**SECTION 4.55(1A) MODIFICATION APPLICATION (SSD 7173 MOD 5) FOR PROPOSED AMENDMENT TO THE SUBDIVISION PLAN**

**PROPERTY AT: 585-649 MAMRE ROAD, ORCHARD HILLS (LOT 2171 DP 1153854)**

Proposed Amendment to the Subdivision Plan – Proposed Lots 10, 11 & 12, 585-649 Mamre Road, Orchard Hills

Enclosure 2a - Proposed Subdivision -

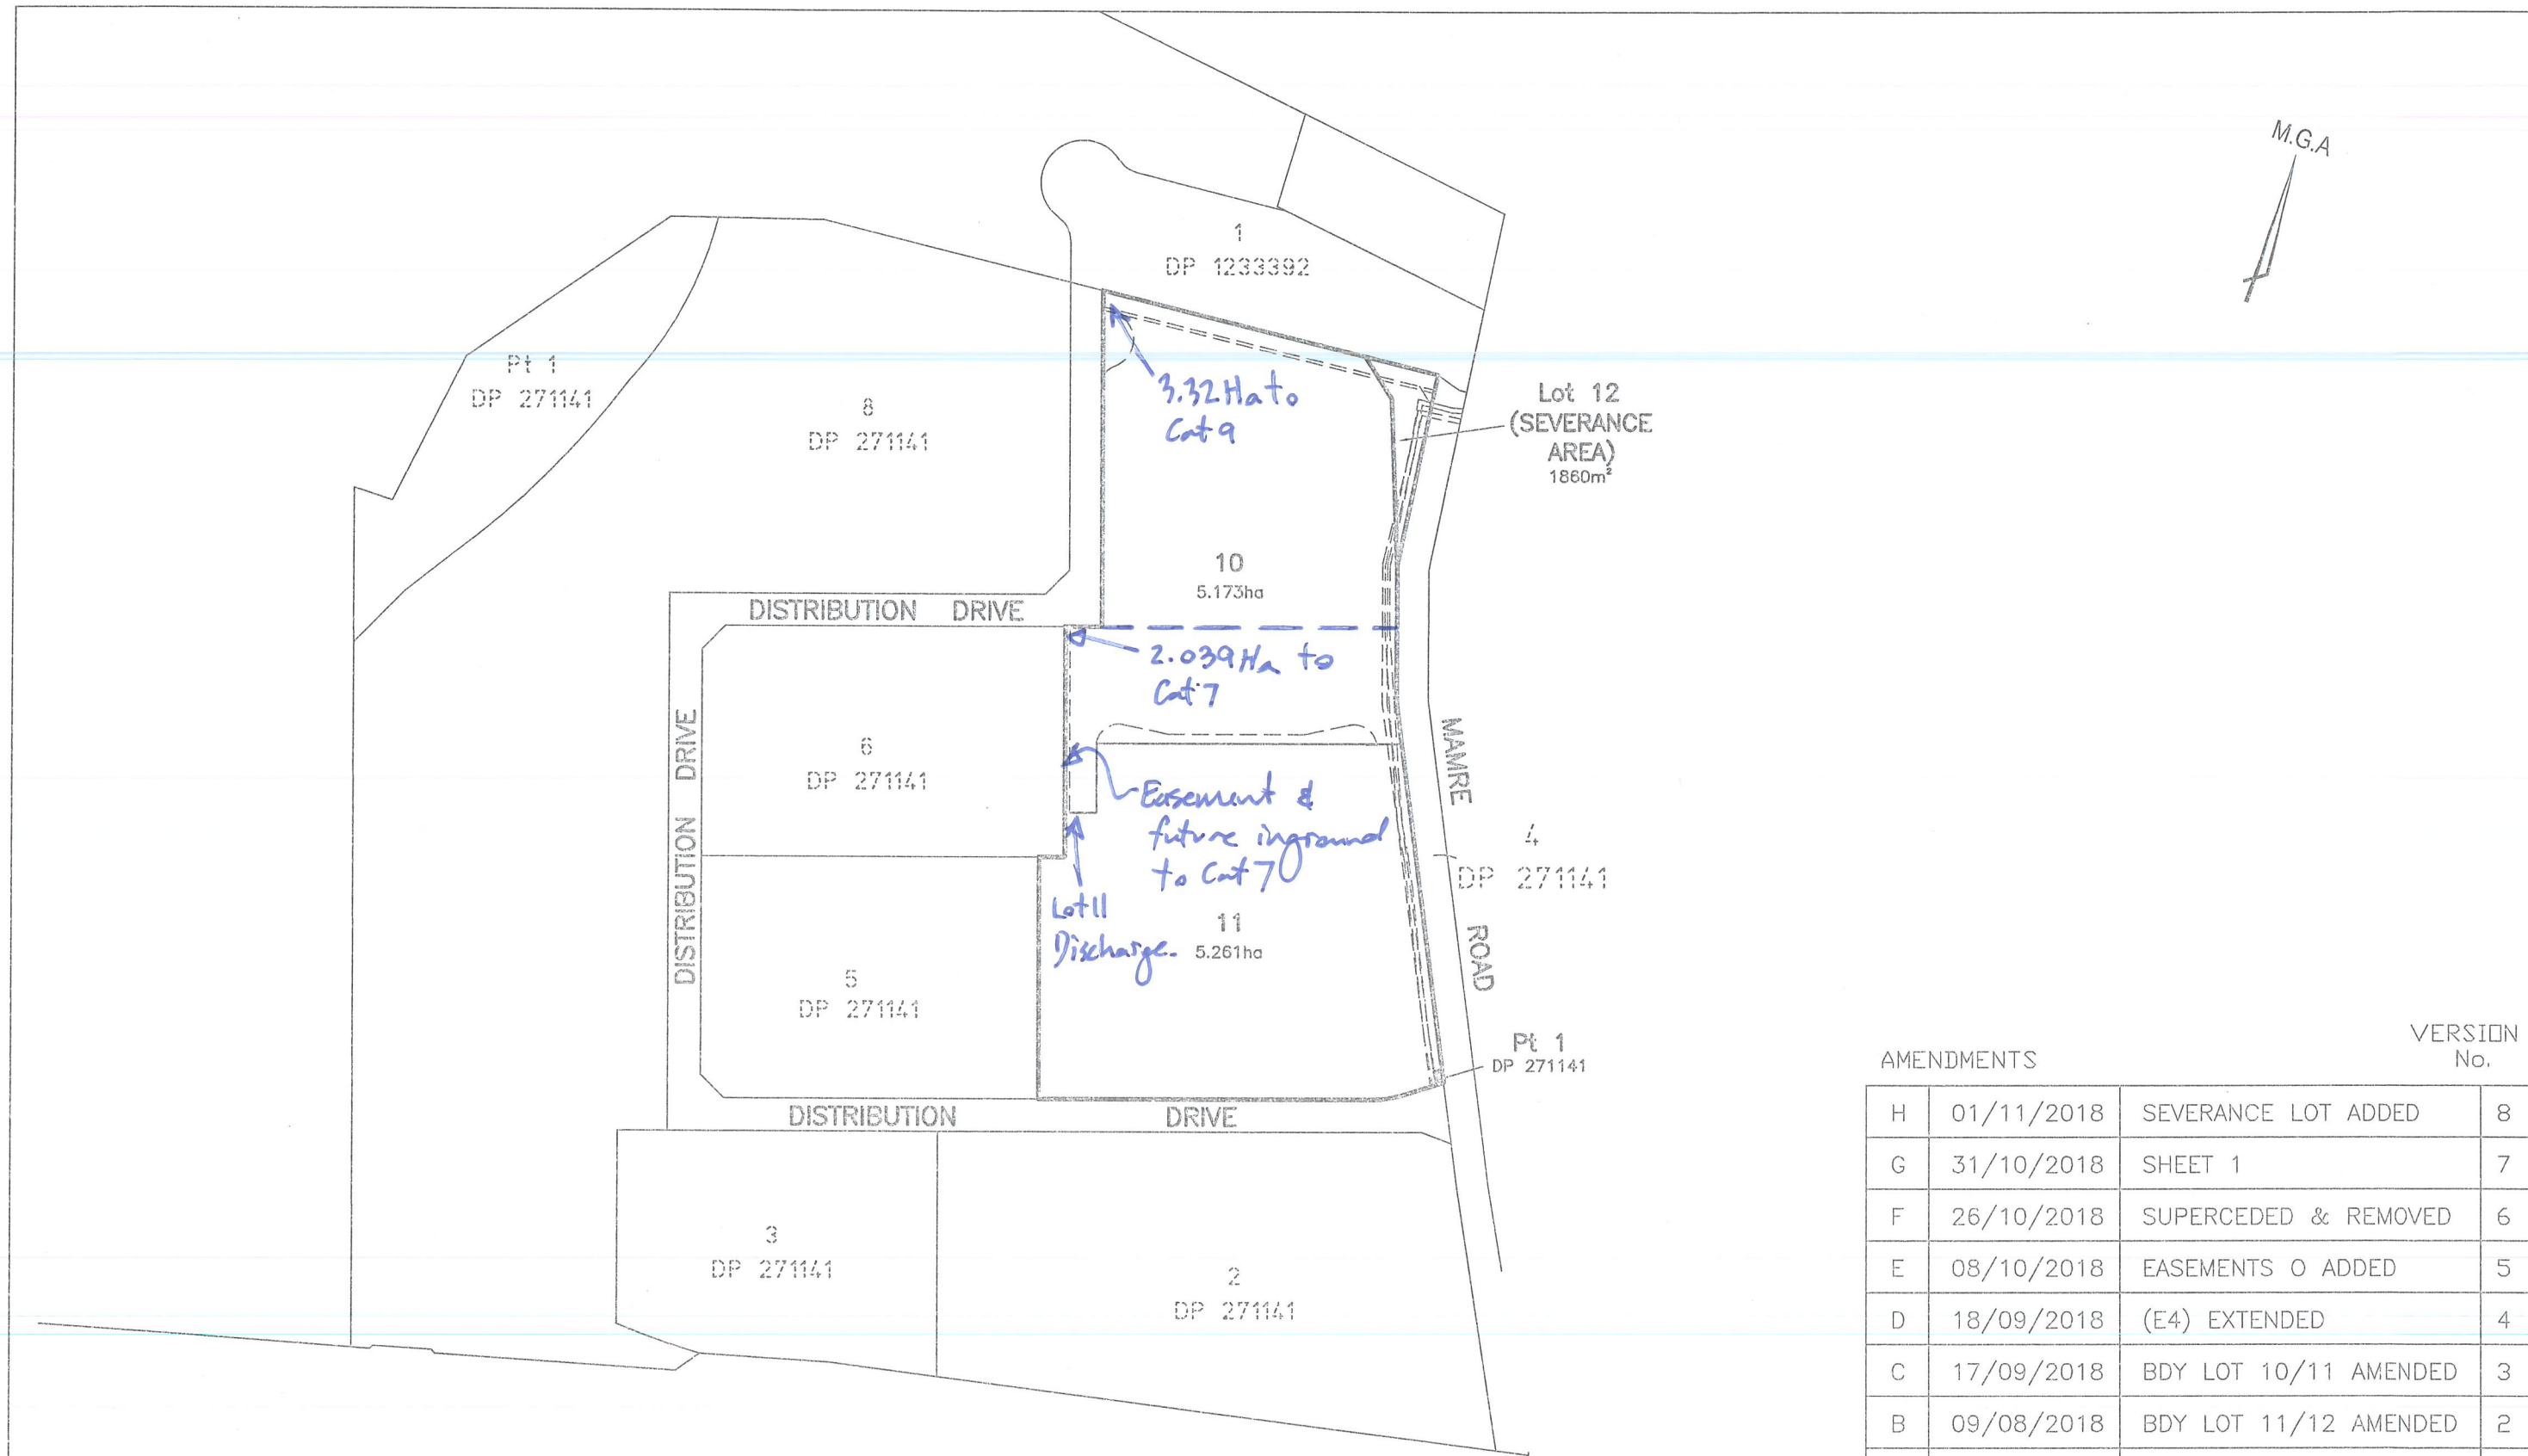
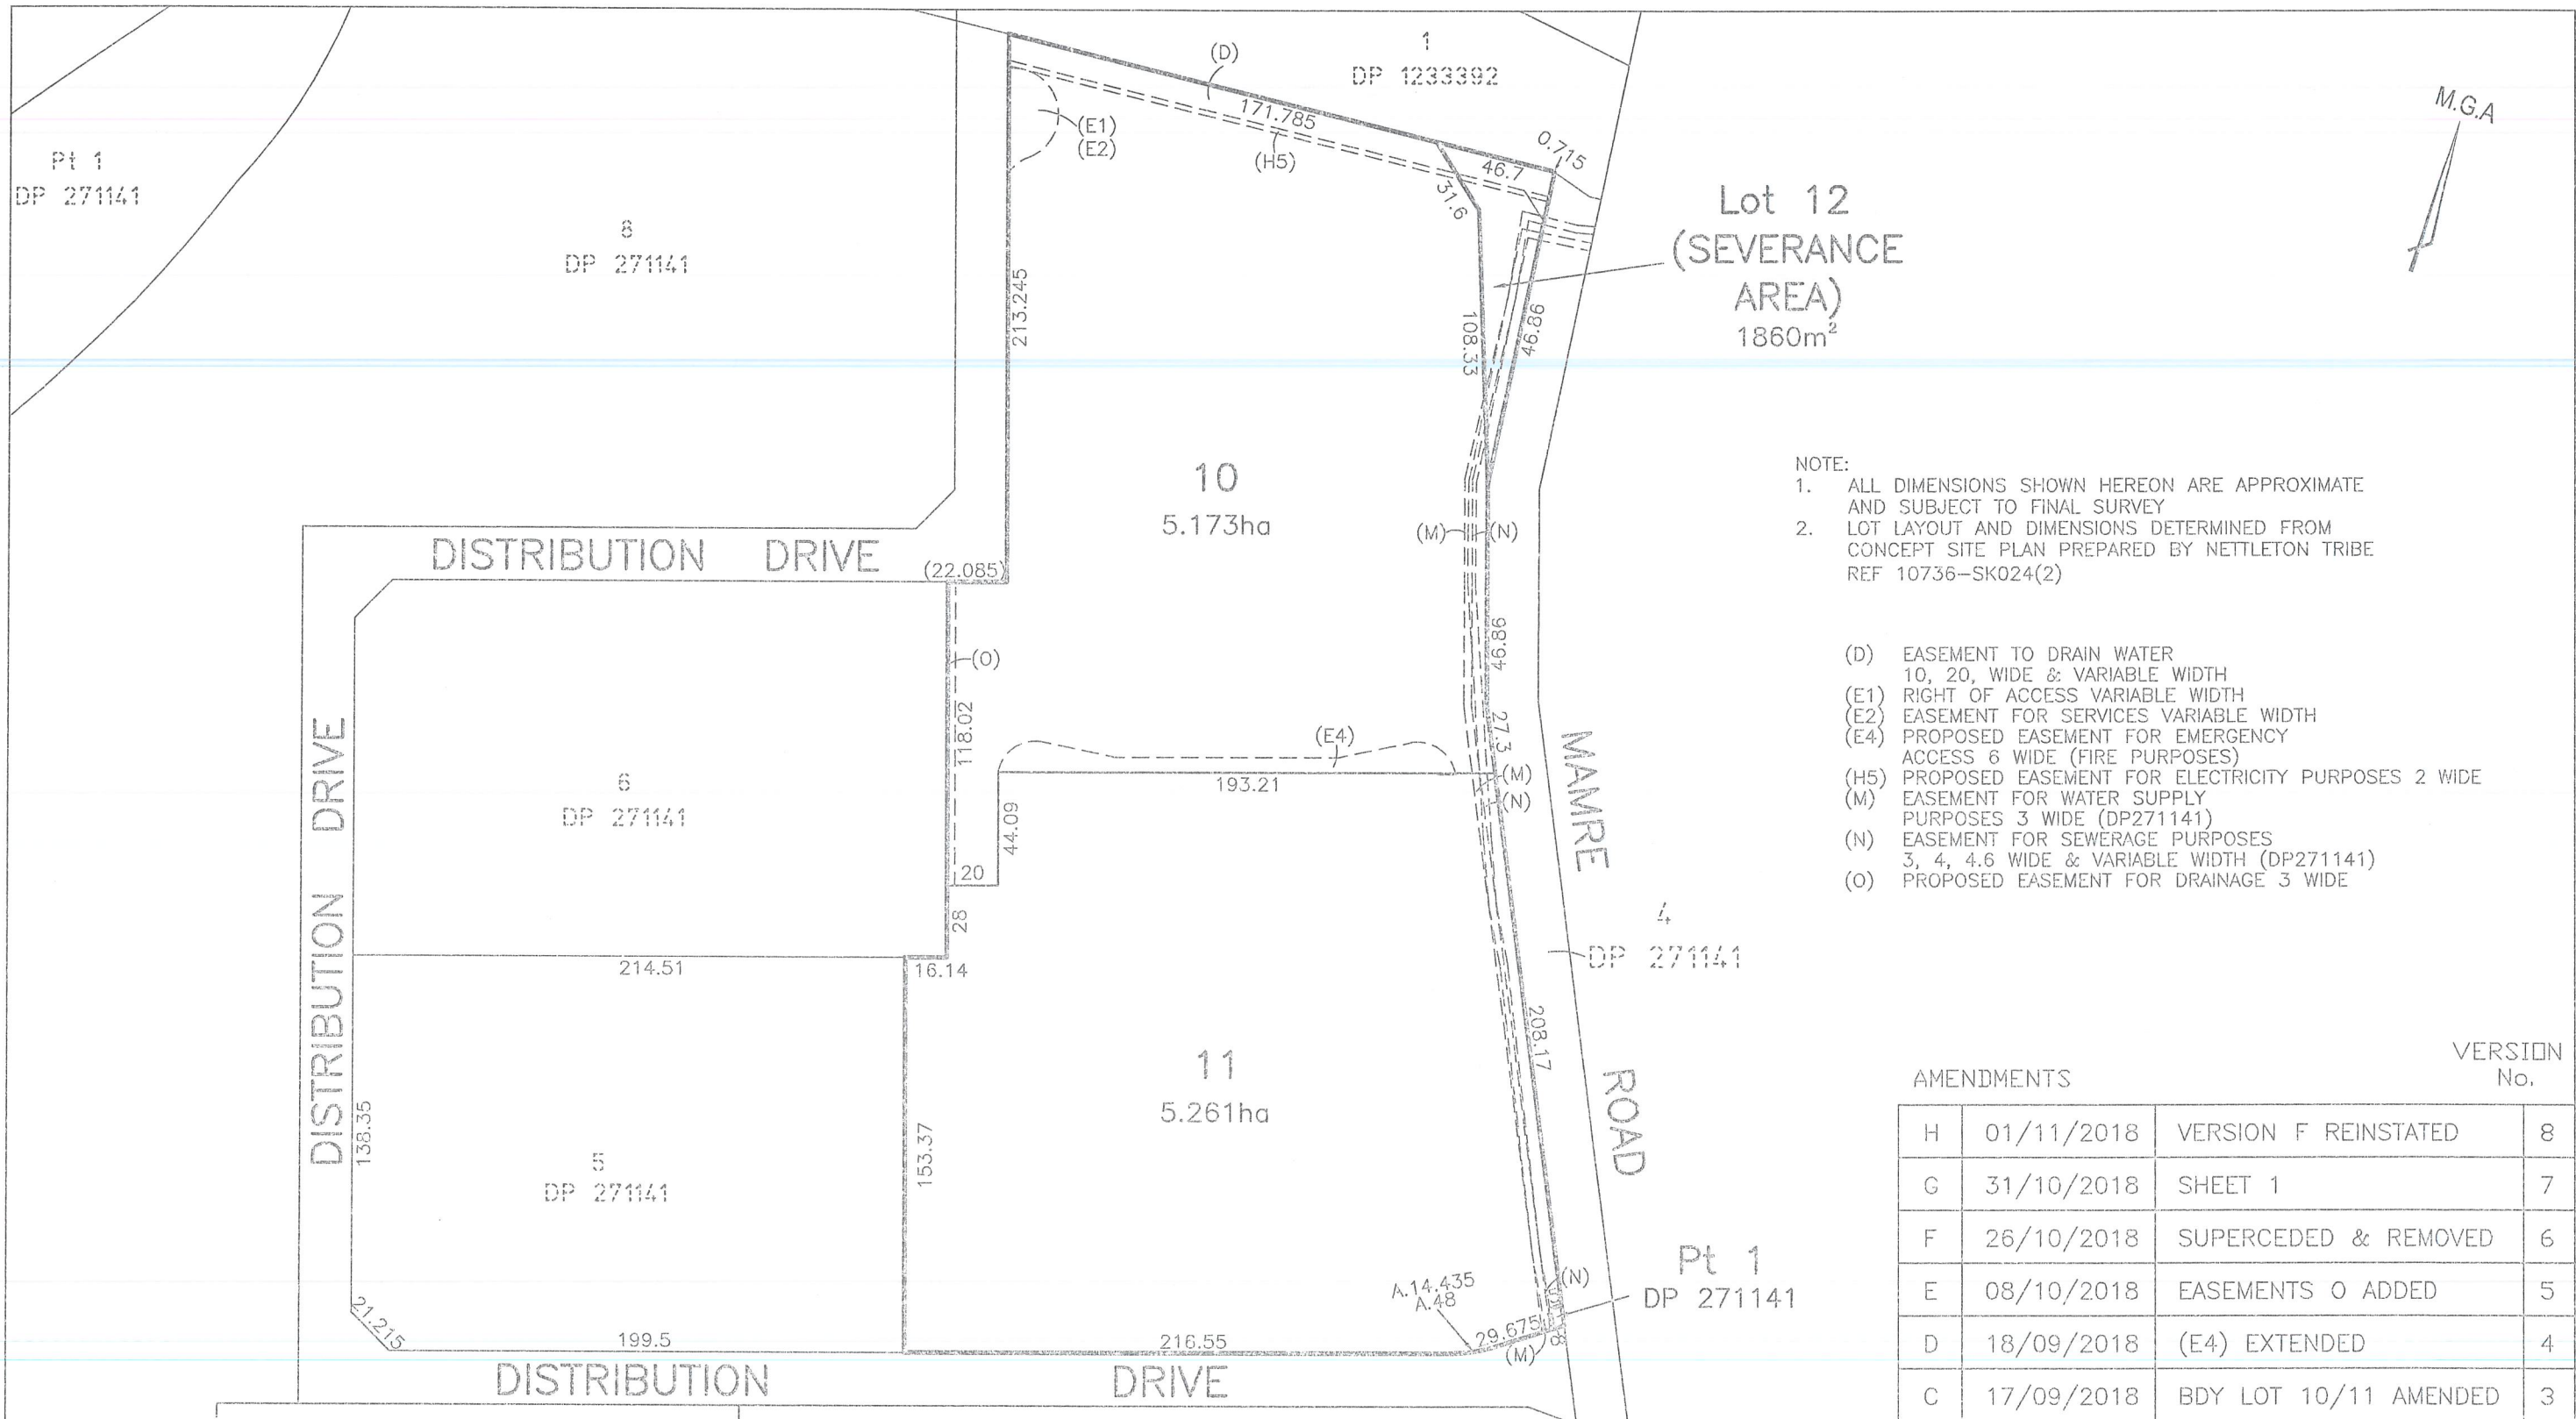
| Table 1: Response Matrix   |  |
|--|--|
| <p><b>Planning Considerations:</b></p> <p><i>The rationale for the creation of irregular boundary lines between proposed Lot 10 and Lot 11 and the creation of Lot 12 is not clear and requires clarification to address orderly development principles. The following clarification is therefore sought to enable further consideration of the proposal:</i></p> <ul style="list-style-type: none"> <li><i>The applicant is requested to confirm the strategic intention for Proposed Lot 12 (severance area). It would appear that this lot is potentially being set up for future road widening of Mamre Road or an intersection upgrade for future road works. The statement as submitted does not address this adequately and references future consolidation with Lot 1 without explanation as to how Proposed Lot 12 is related to Lot 1 and what the long term strategic intention is for these resulting severed allotments. To consider the appropriateness of lot creation, the intended use and function of the proposed lots must be understood and the resulting boundaries of proposed Lot 12 must be sufficient to achieve its intended function, without future impost on Lot 10 if severance is sought at this point in time.</i></li> </ul> | <p>The strategic intention proposed for the Subject Site (First Estate), with regard to proposed Lot 12 is indicative of the future road widening of Mamre Road, which would subsequently impact on the following land portions, including:</p> <ul style="list-style-type: none"> <li>Proposed Lot 12; and,</li> <li>Lot 1 DP 1233392.</li> </ul> <p>The intention is to amalgamate both identified lots pursuant to the road widening taking place; hence, why proposed Lot 12 is not being serviced at this point in time, as it will be serviced through augmentation of the allotment to the north.</p> <p>As mentioned above, a future DA will be undertaken and submitted to the relevant consent authority, for which the proposed development would utilise the permissibility of the IN1 General Industrial zone under <i>State Environmental Planning Policy (Western Sydney Employment Area) 2009</i> (SEPP WSEA), for which both land portions are zoned accordingly under the SEPP. A draft schematic further illustrating the potential outcome of the identified land portions is provided in <b>Appendix 2</b>.</p> <p>Additionally, the intention behind proposed Lot 12, is considered to be in accordance with the Conditions of Consent provided by the NSW DP&amp;E with regard to SSD 7173, including Condition "C1", concerning 'access' that specifies the following:</p> <ul style="list-style-type: none"> <li>"This internal access road shall: <ul style="list-style-type: none"> <li>(a) Be linked to the proposed James Erskine Drive and Mamre Road intersection (fourth leg) (as proposed by RMS and depicted in the gazetted Access Strategy in the Mamre West Land Investigation Area Development Control Plan, August 2016), once constructed."</li> </ul> </li> </ul> |

| <ul style="list-style-type: none"><li>▪ <i>The internal boundary arrangement of the approved subdivision plan (as per SSD 7173 MOD 2) seems more logical and provides for regular shaped lots. The boundaries of proposed Lot 10 and 11 subject of this application are now irregularly shaped and it is unclear as to the benefit/reasoning behind the proposed subdivision pattern as revised. While the statement of environmental effects references separate development applications (SSD9429) for built form works, it is not clear how this separate application dictates or requires the irregular boundary conditions proposed as part of this modification application.</i></li></ul> | <p>Proposed Lot 12 would respond accordingly to Condition C1 mentioned above, via the future inclusion of a slip lane and future proposed development, which would satisfy the condition imposed, ultimately linking the internal access road to Mamre Road and James Erskine Drive (once upgraded / constructed).</p> <p>The proposed allotment boundaries have been designed in accordance with the operational requirements of the end user (Snack Brands). The irregular area on Lot 10 adjacent to the western boundary is intended to provide a space for future infrastructure that will be required to serve the stage 2 development. This infrastructure will need to be located on the same lot as the future development for Authority compliance. This area was selected to mitigate the visual impact of the future infrastructure from the Mamre Road and Distribution Drive.</p>   |
